SWPPP COMPLIANCE INSPECTION REPORT

Date of Inspection	Tuesday, October 22, 2019
Project	Coors Village Offsite
Location	Western Trails and Coors Blvd

NPDES #	NMR10022T/NMR10022M
Permit Type	Construction General Permit
Inspection Type	14 day SWPPP Compliance Inspection

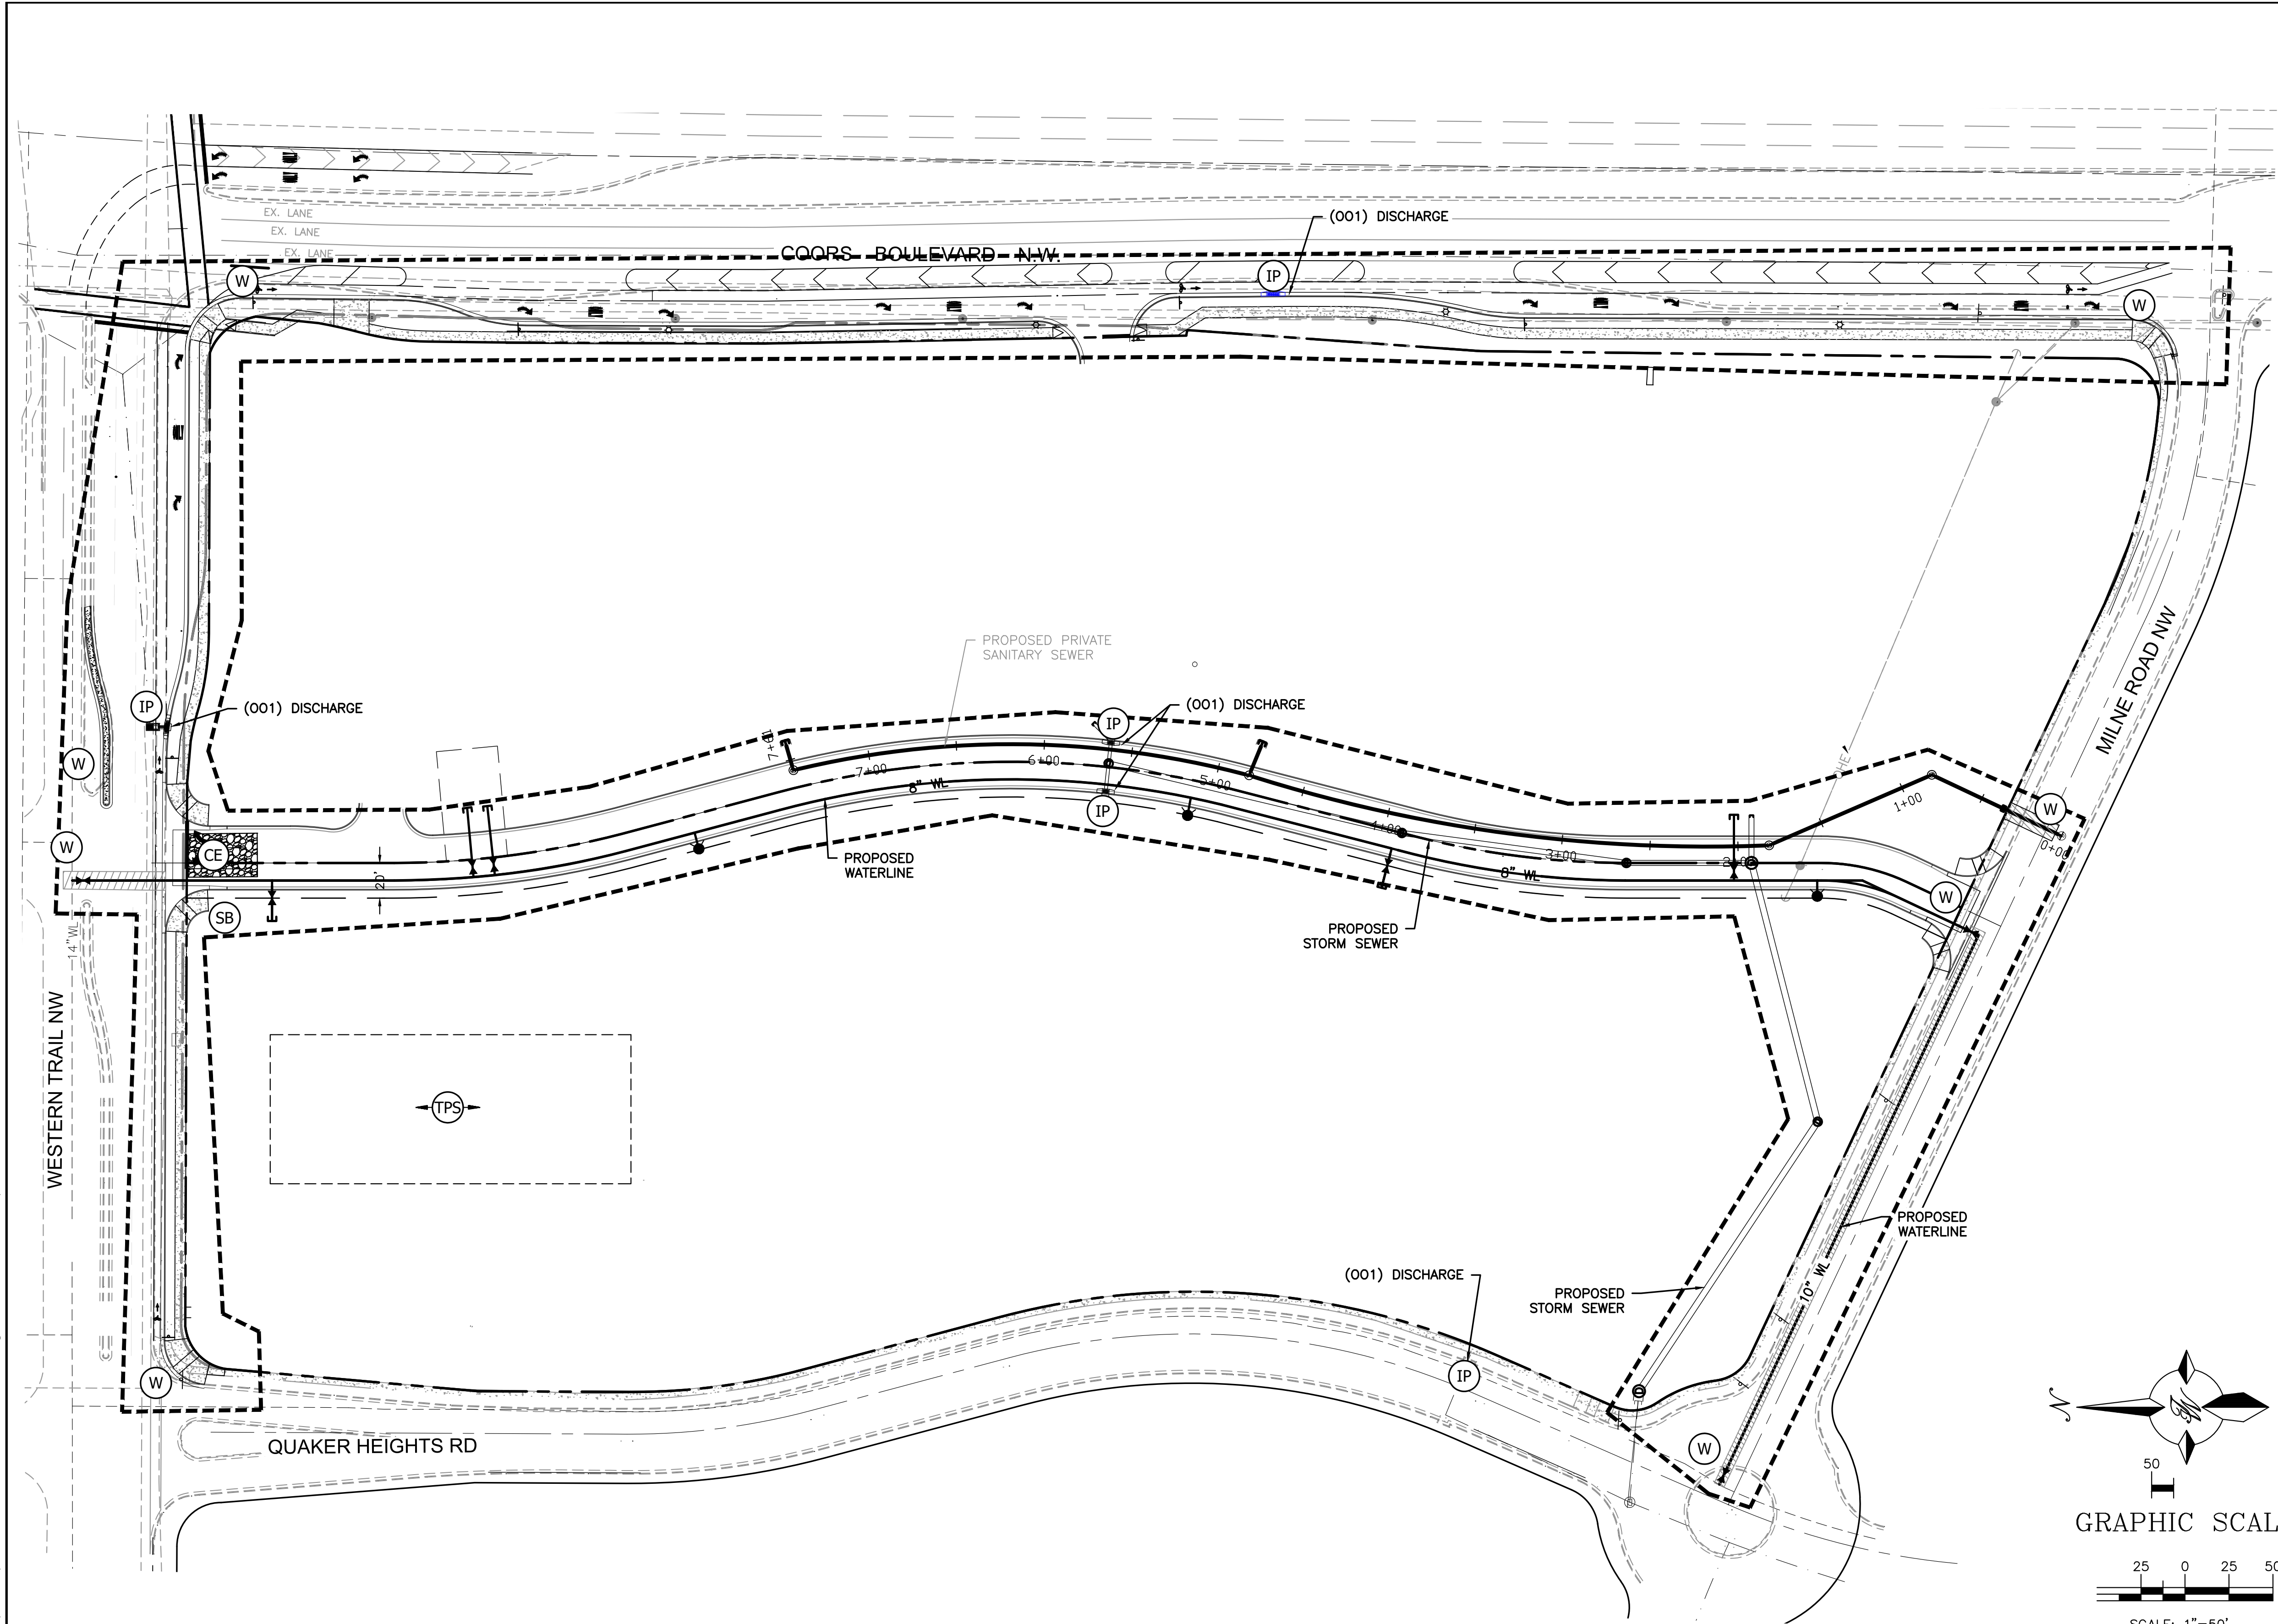
Is there Evidence of a Discharge Since Last Inspection?		Yes
Was a discharge observed in progress?		No
Location:	N/A	
Discharge Description :	It appears that sediment has been infiltrating the inlets in the new roadway.

POLLUTION PREVENTION, SEDIMENT AND EROSION CONTROLS			
List Any BMP's Or Controls That Require Maintenance or Corrective Actions?			
Control	Location	Issue	Maintenance or Corrective Action?
Entrances/ exits	All access points	Track out	Sweep clean daily
Wattles	Quaker Heights	Flattened	Replace
Silt Fence	South of private roadway	Displaced, sagging, not functioning	Re-set
Permanent Stabilization is now required of all disturbed areas

Please sweep any sediment in the roadway back into the site at the end of each day.

The inlets require inlet protection.
